Department of Planning & Infrastructure

***Modification Request for the University of Sydney Abercrombie Precinct Redevelopment:
Application Number: MP07_0158 MOD 3***

Title
Scale
Date
Number
0 2 4
10 20m
Ground Floor Plan
MARK UP SET
1:200@A1
11.10.13
4001_DA02-D
© copyright nettleton tribe partnership pty ltd

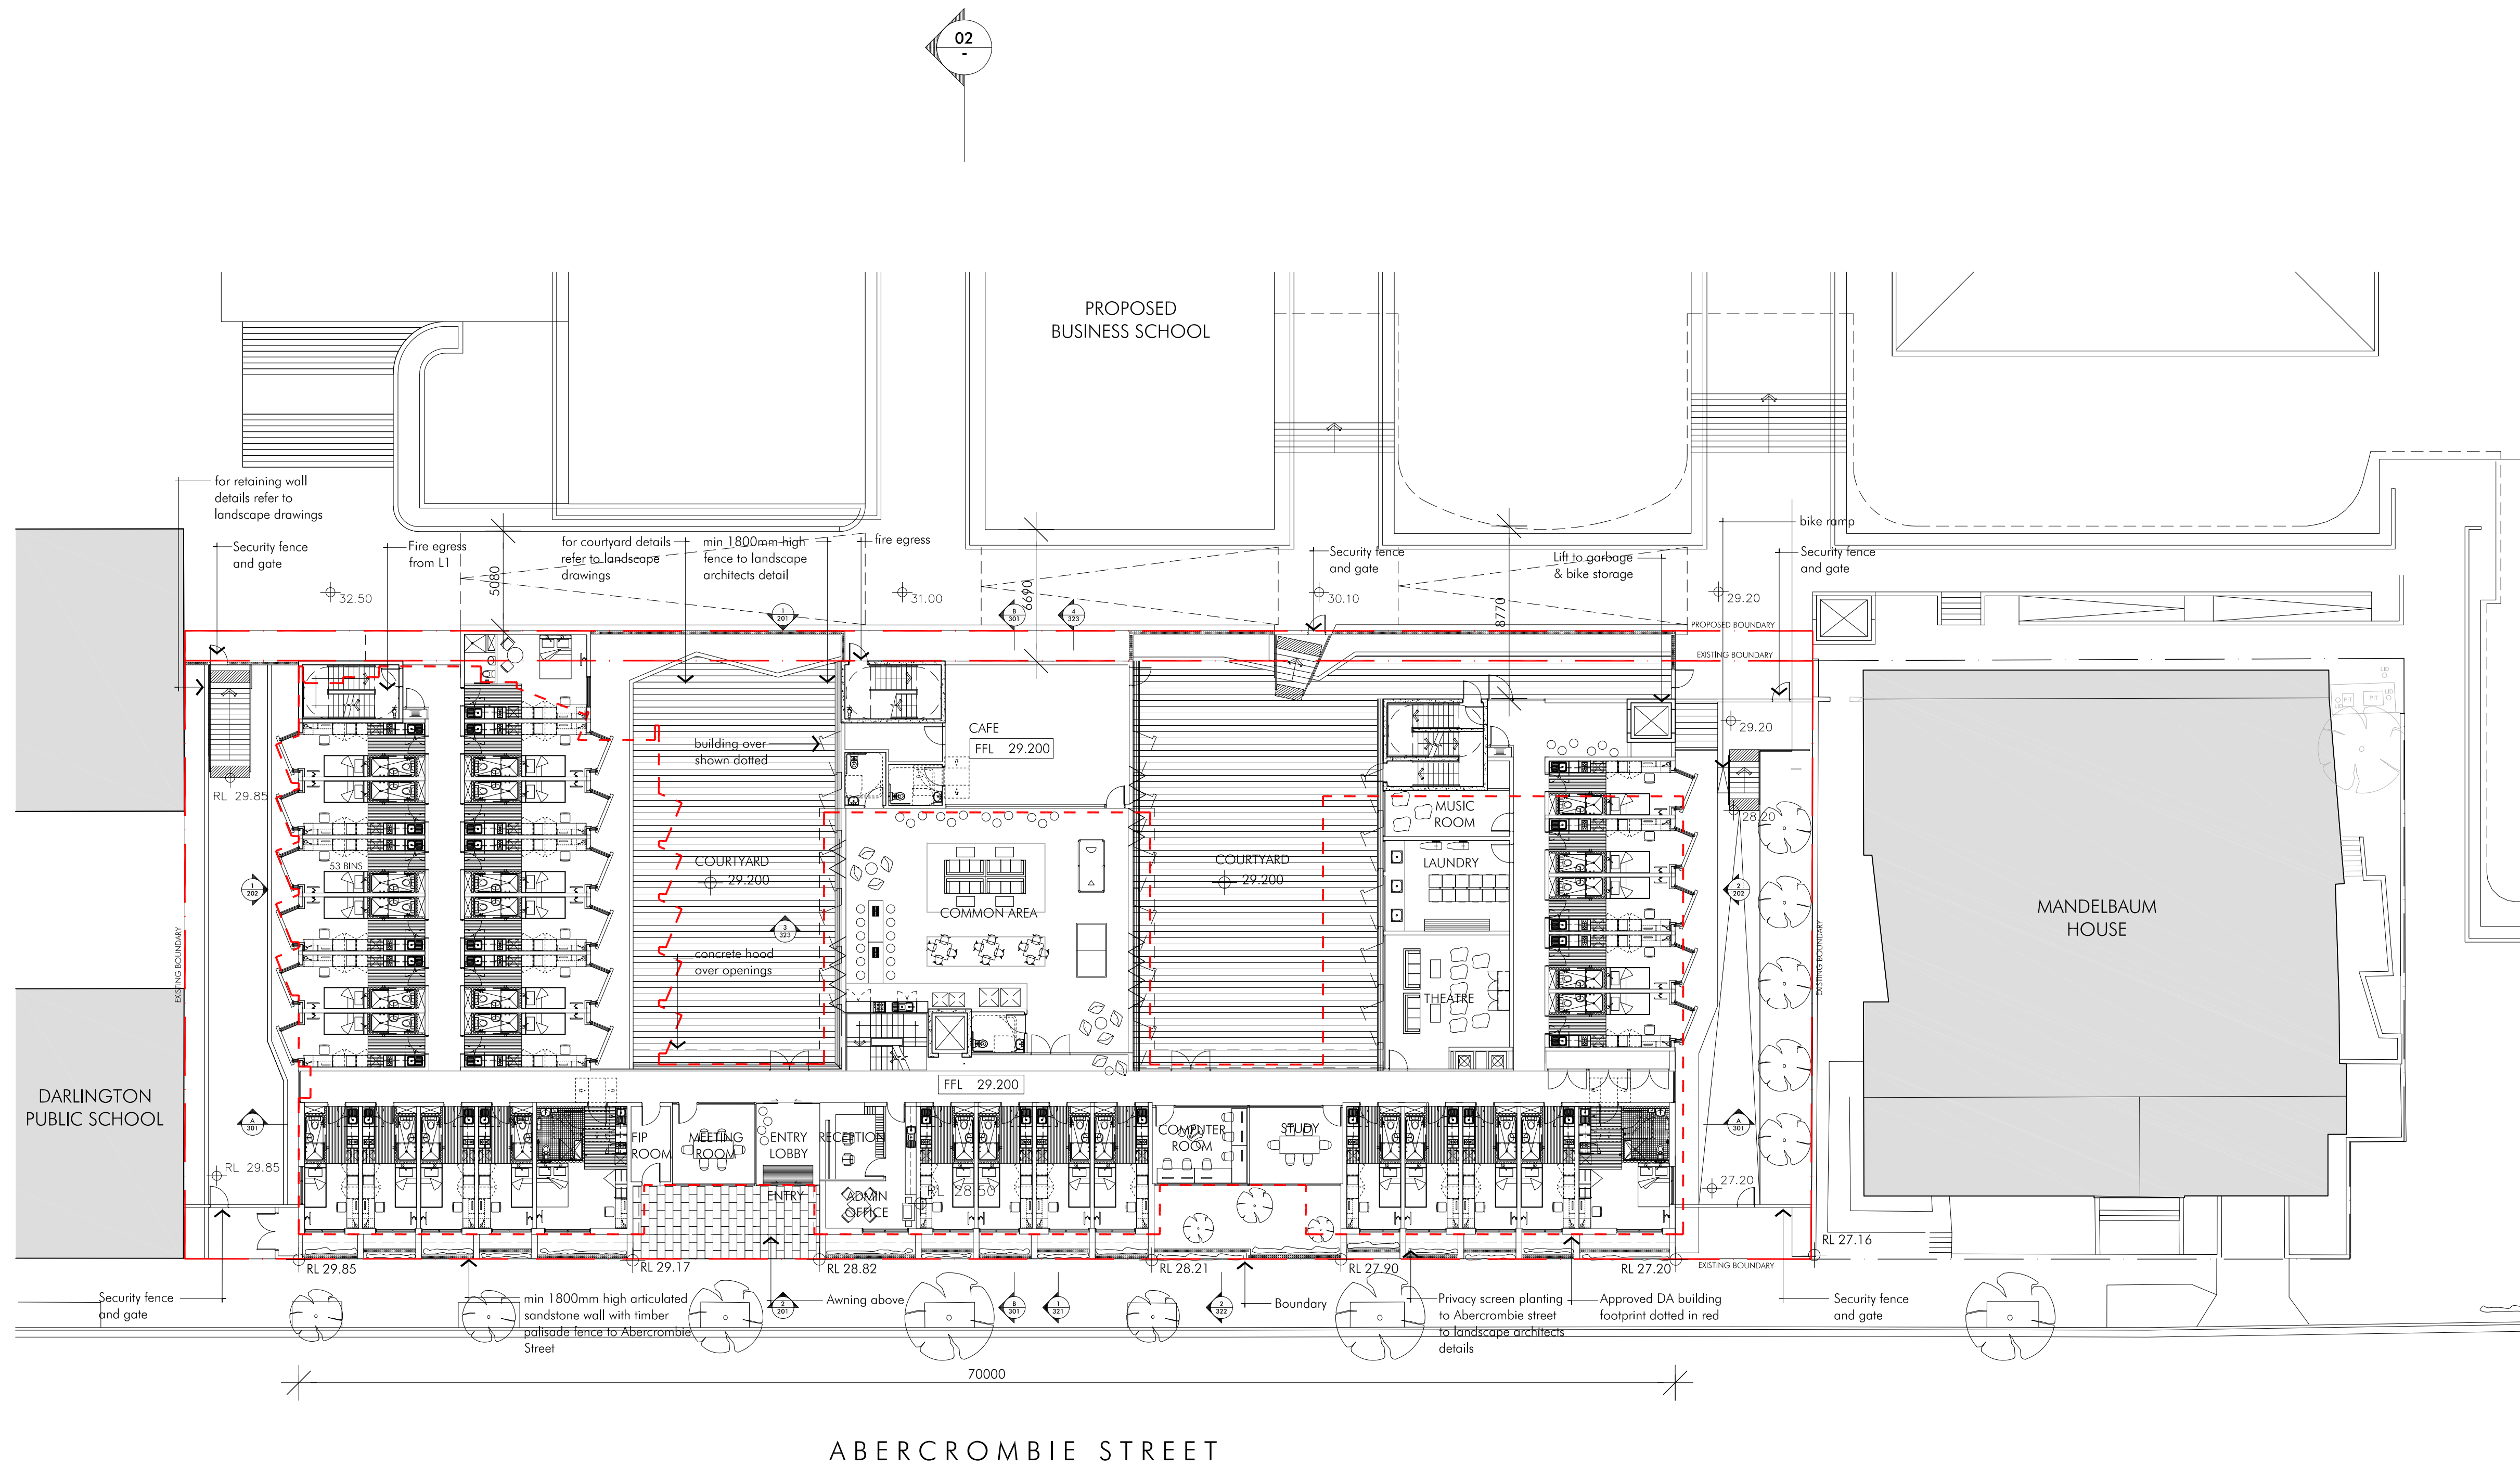
- The front of the Student Accommodation building should be built 2 metres back from the Abercrombie Street boundary. It should be set back from this boundary so that it is in line with Mandelbaum House as it was originally planned and presented to the community. The footprint of the buildings currently on the site, The Shepherd Centre and Boundary Lane Children's Centre, is approximately 2 metres back from the Abercrombie Street boundary and aligns with Mandelbaum House. Therefore, the front footprint of the proposed Student Accommodation building should be the same as those buildings currently occupying the site and as originally planned. The footprint of the proposed Student Accommodation building should not extend to the Abercrombie Street boundary.

- The facade of the proposed Student Accommodation building does not reflect the heritage appearance of the Victorian terraces opposite on Abercrombie Street as Mandelbaum House does. Therefore, it should be set back to allow for extensive vegetation and trees to be planted in front of the building on Abercrombie Street to help preserve the heritage streetscape and improve both the aesthetics and the environment of the street.
